RE: Planning application AW/353/14/PL
11, Marquis Way, Bognor Regis, PO21 4AT

I wish to object to the proposed demolition and rebuild of 11, Marquis Way, Bognor Regis, PO21 4AT.

Planning Ref. AW/353/14/PL

project: 11 Marquis Way - Aldwick			
drawing title: Proposed Site Plan			
drawing status: Planning Application			
date: 09 - 12 - 2014	scale at relevant drawing size 1 : 50 (A1) or 1 : 100 (A3)	no: JW131105 - PL10	rev.: -

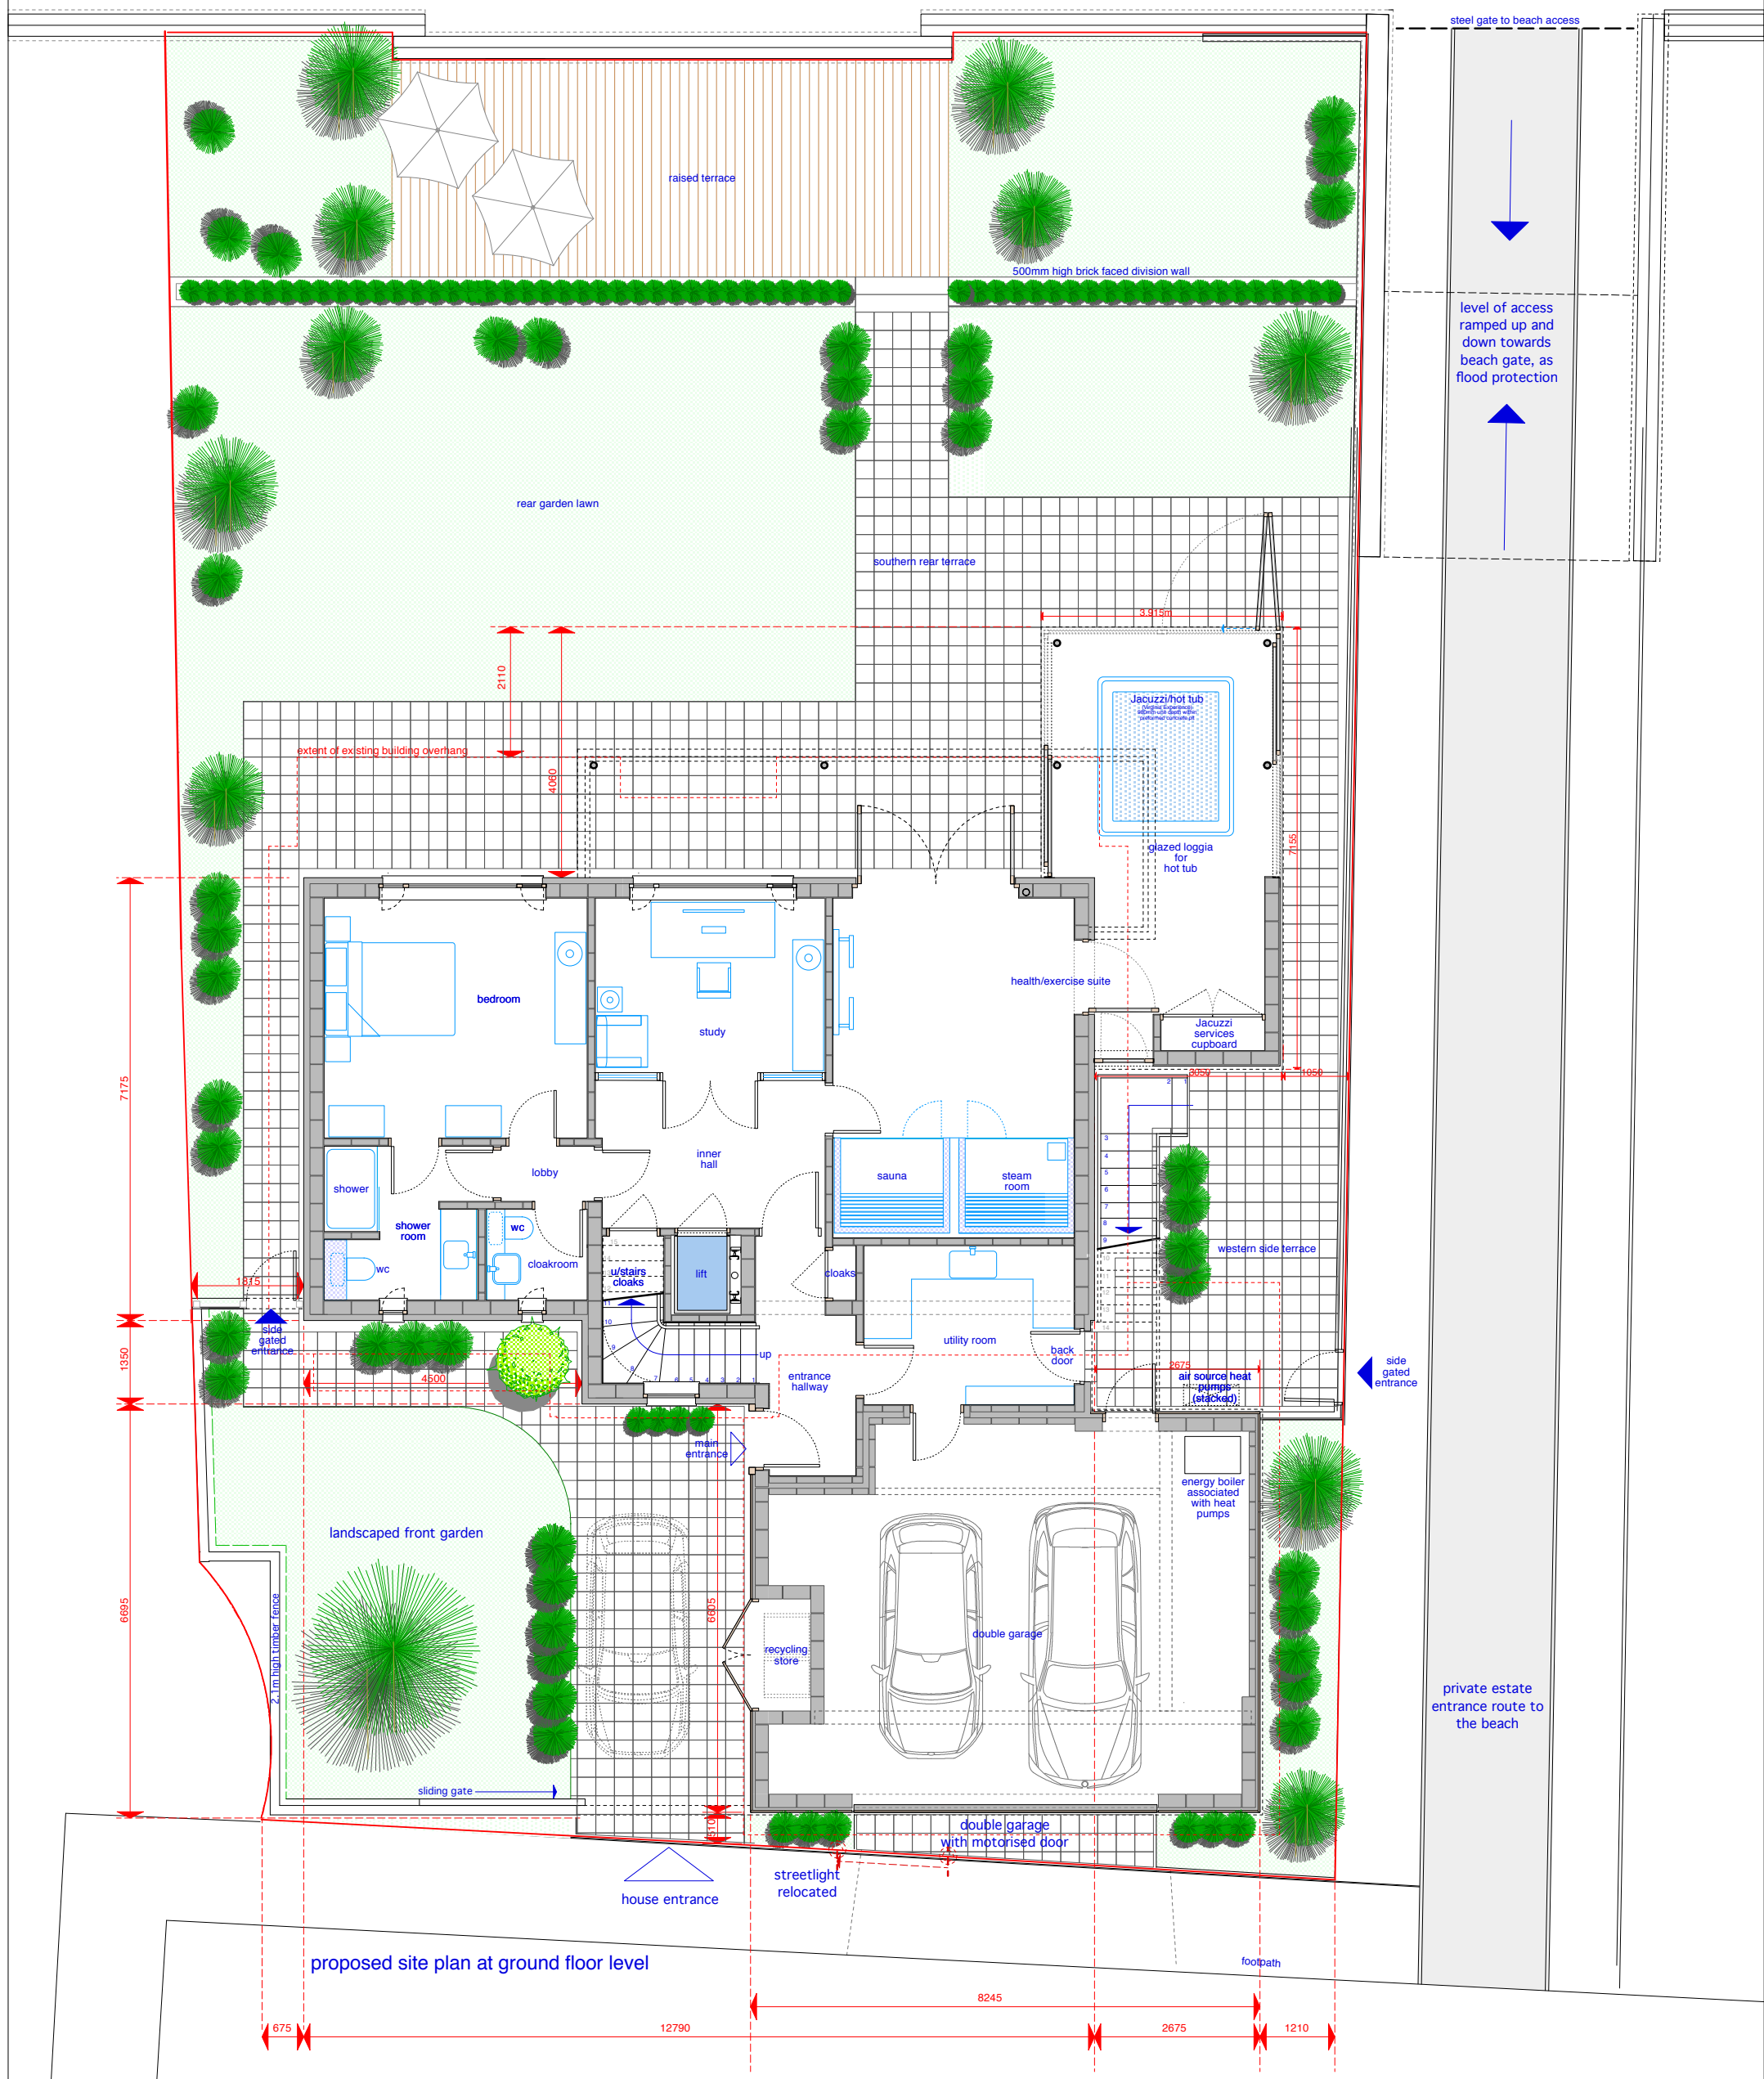
Design and Appearance. The design and resulting appearance of a flat roofed, rendered house with extensive first floor balconies will differ from all other properties which are constructed of brick with a pitch roof of either slate or concrete tile. The plans show that the south and west facing elevations extended beyond the existing building line. The south facing building line was enforced when planning approval was granted for the extension to No.15

The proposed planning shows access to the garage entering and exiting straight on to the road, which is a T-junction and could cause serious problems for people visiting No's 9, 10, 12,14, and 15. It will also be a danger to residents walking by.

project:	11 Marquis Way - Aldwick		
drawing title:	Existing and Proposed Parking Plans		
drawing status:	Planning Application		
date:	09 - 12 - 2014	scale at relevant drawing size	1 : 100 (A1) or 1 : 200 (A3)
no:	JW131105 - PL16	rev:	-

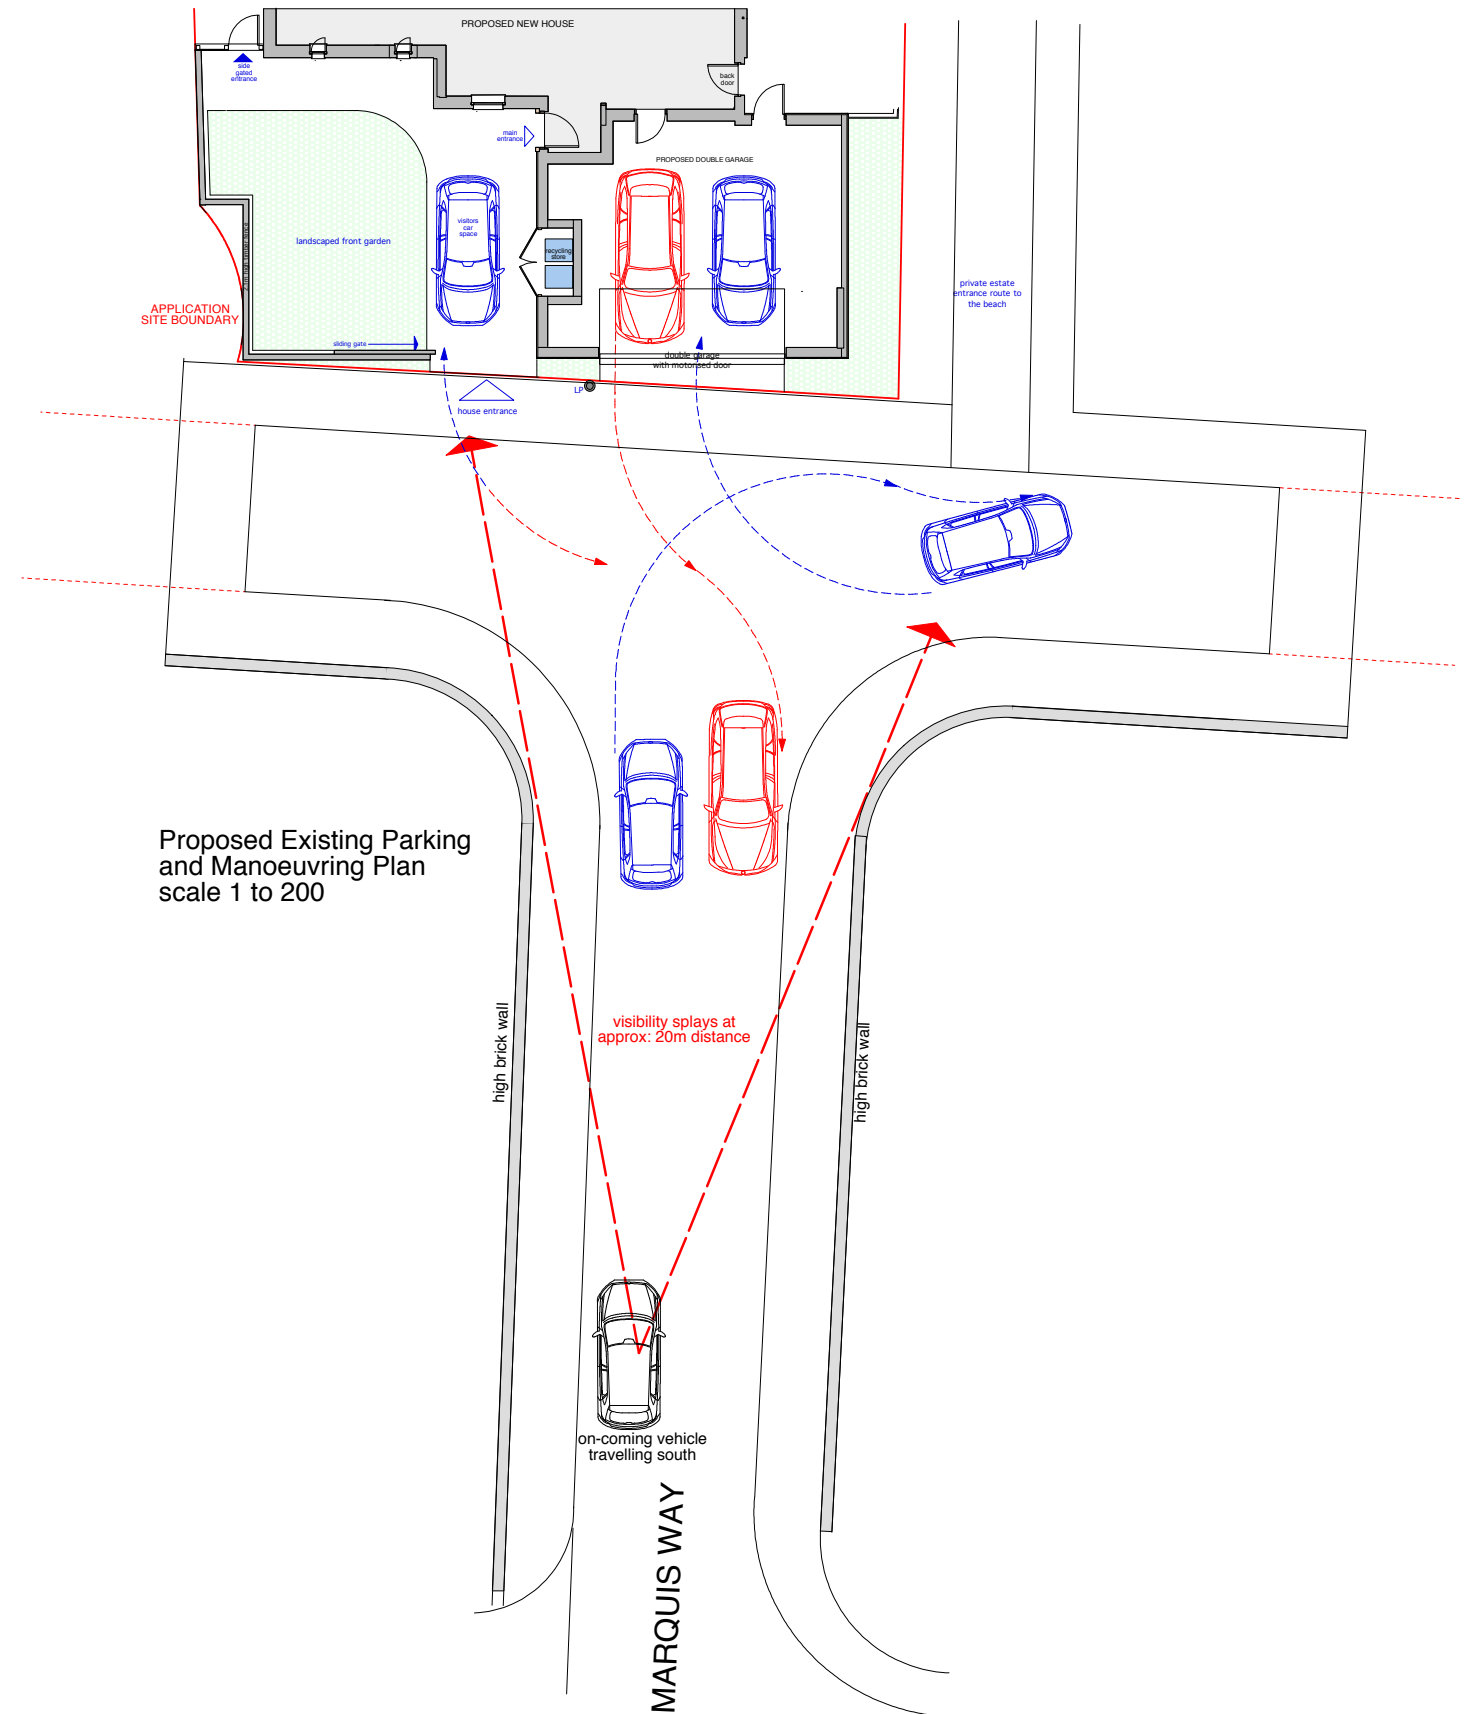
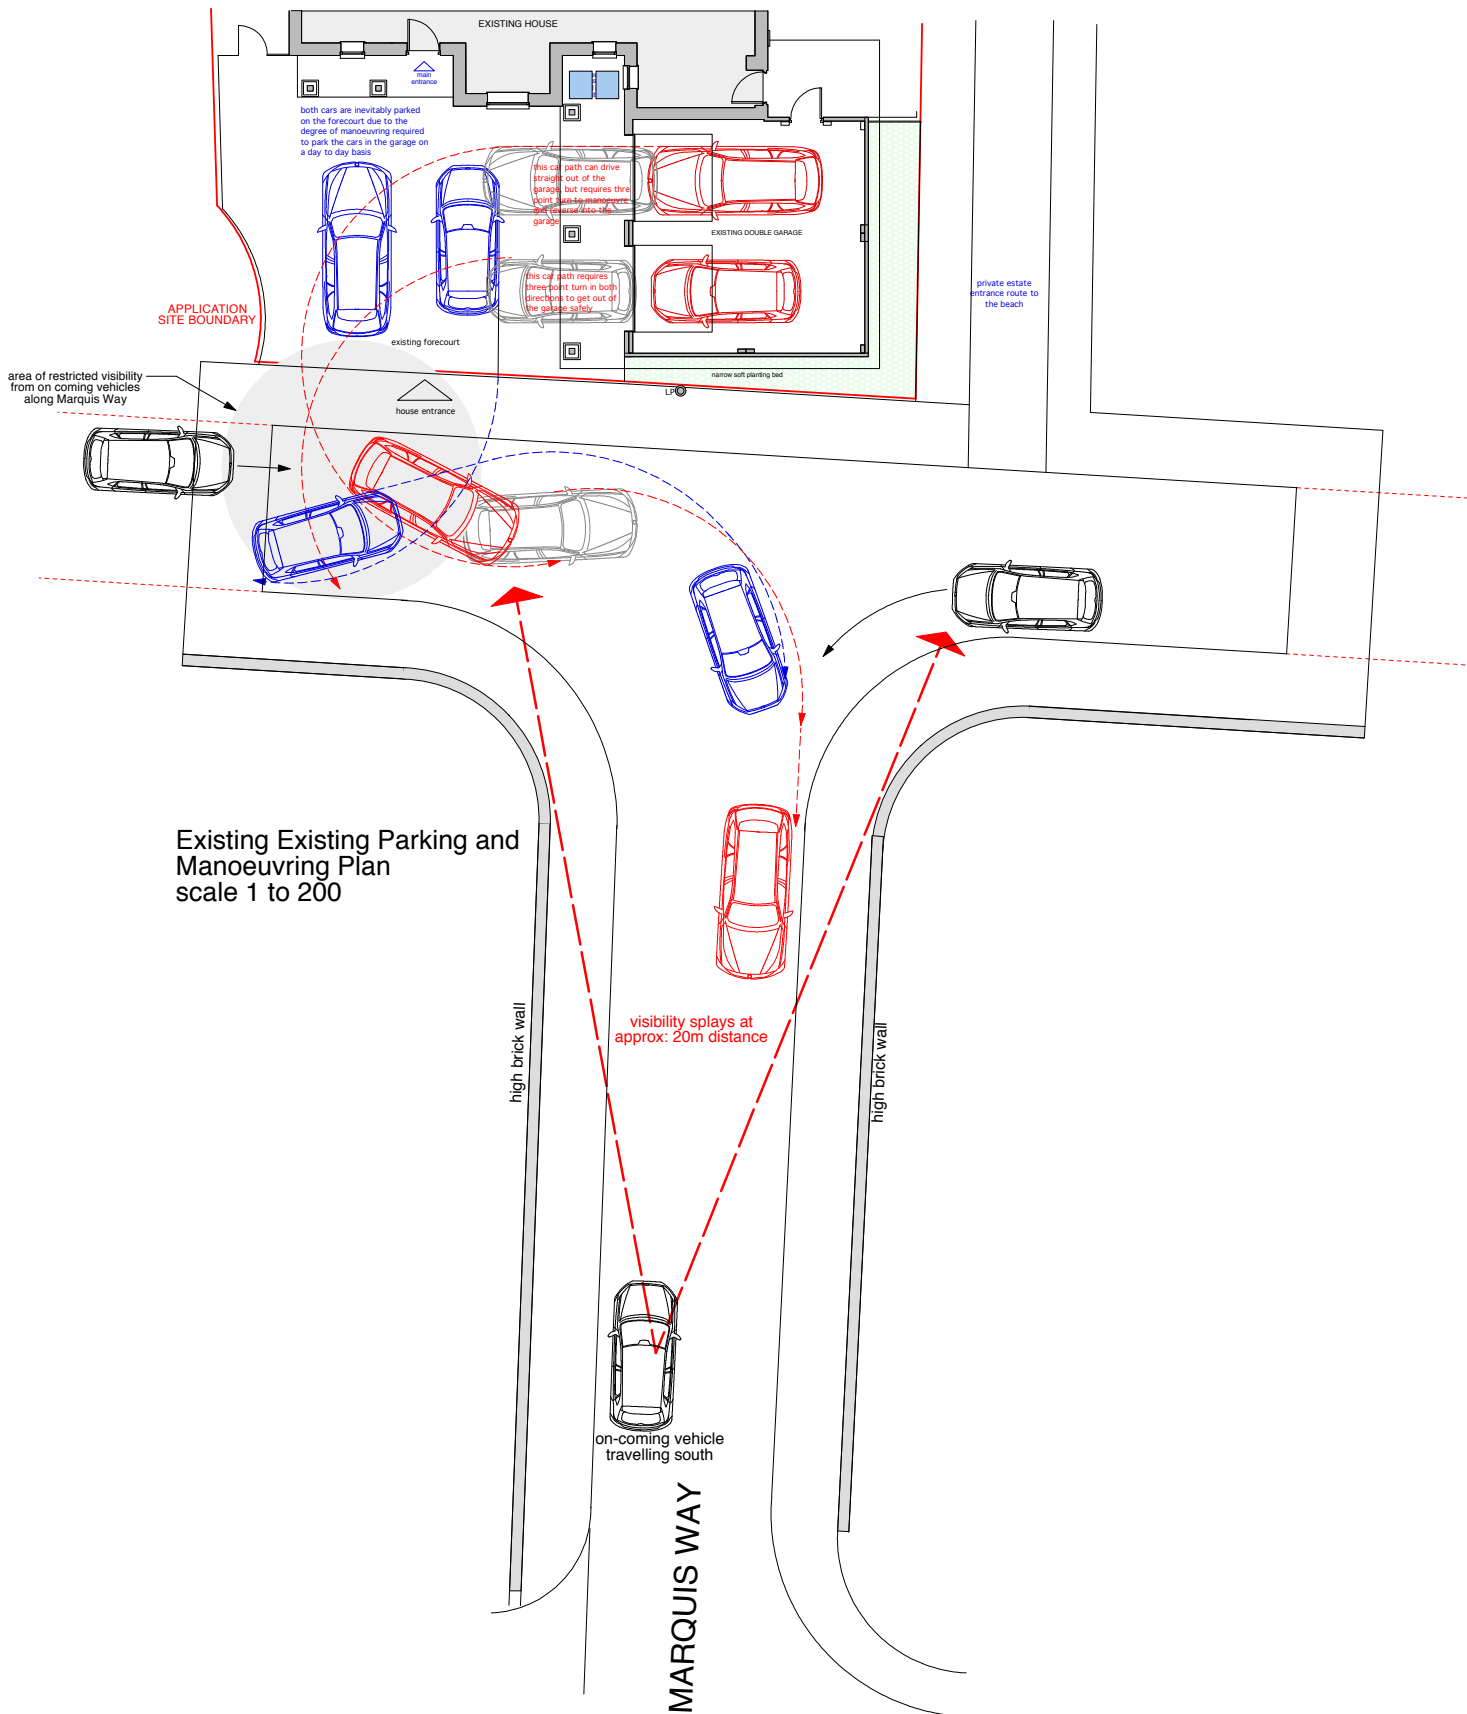
I also feel there will be an issue under Arun Local Plan Gen 7 section (vii) with safe movement of pedestrians. The proposed change in garage site will raise a further issue of garages opening directly on to pavements.

north elevation (from within front garden) and section A - A through first floor front balcony garden onto Marquis Way

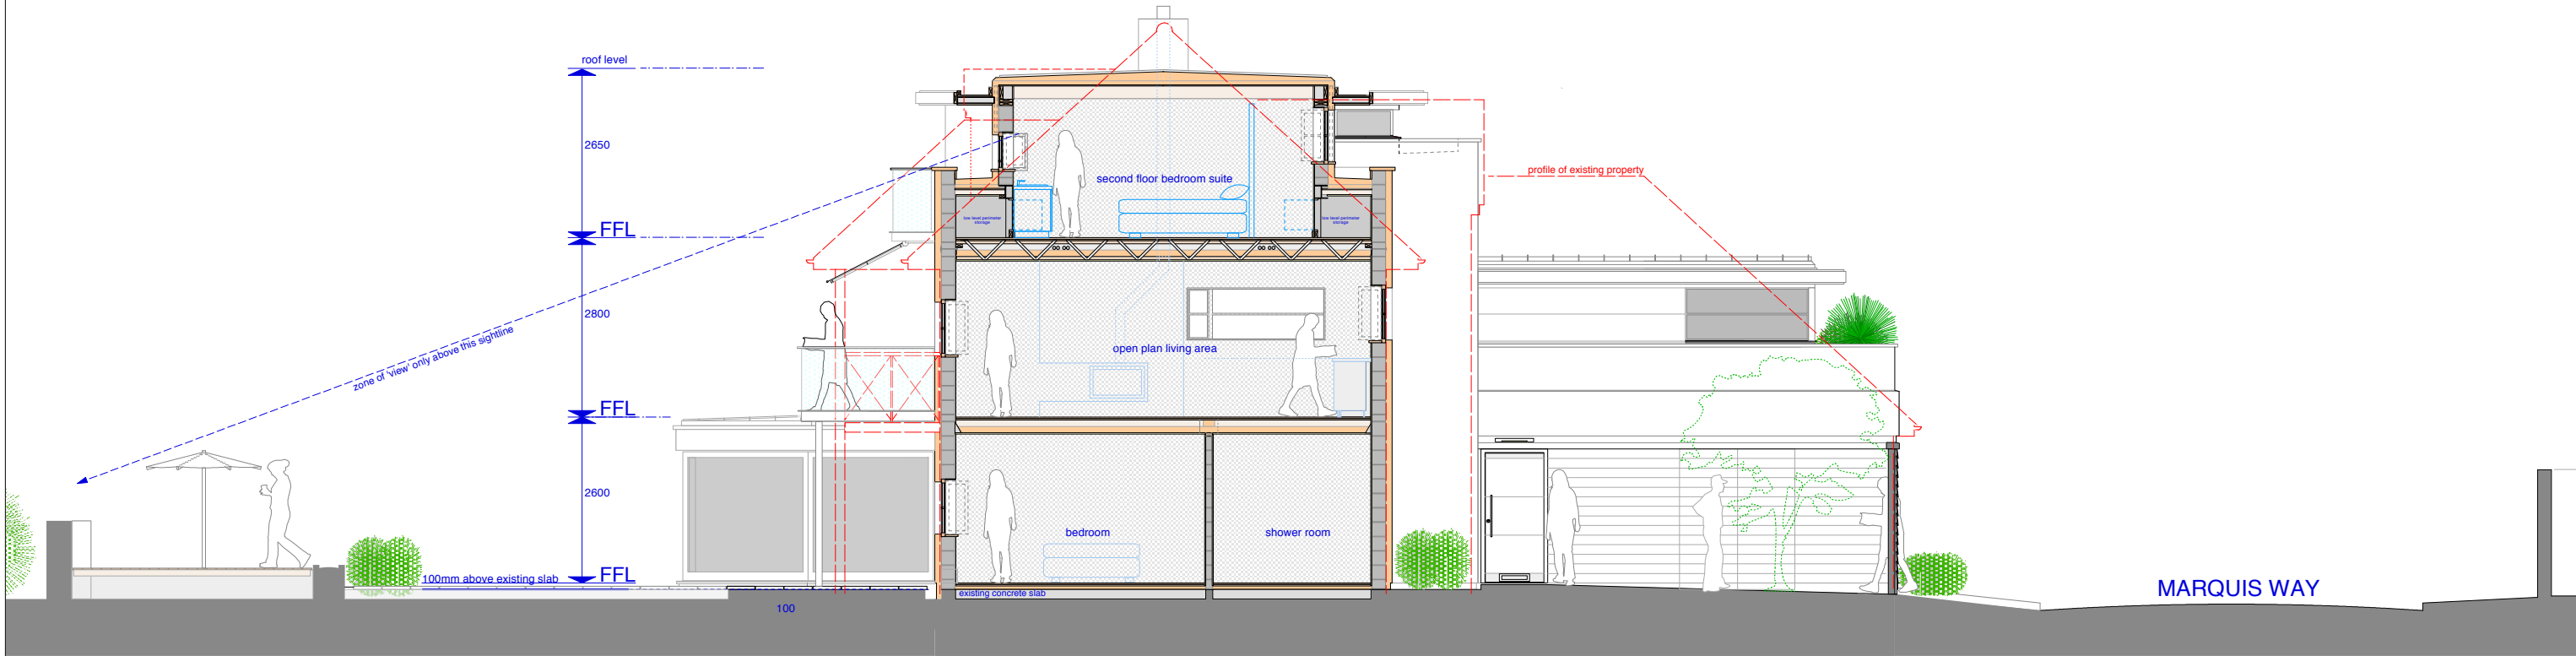
Privacy. A number of properties not currently overlooked will have the intrusion of the first and second floor, west and north facing balconies, with direct site in to their properties.
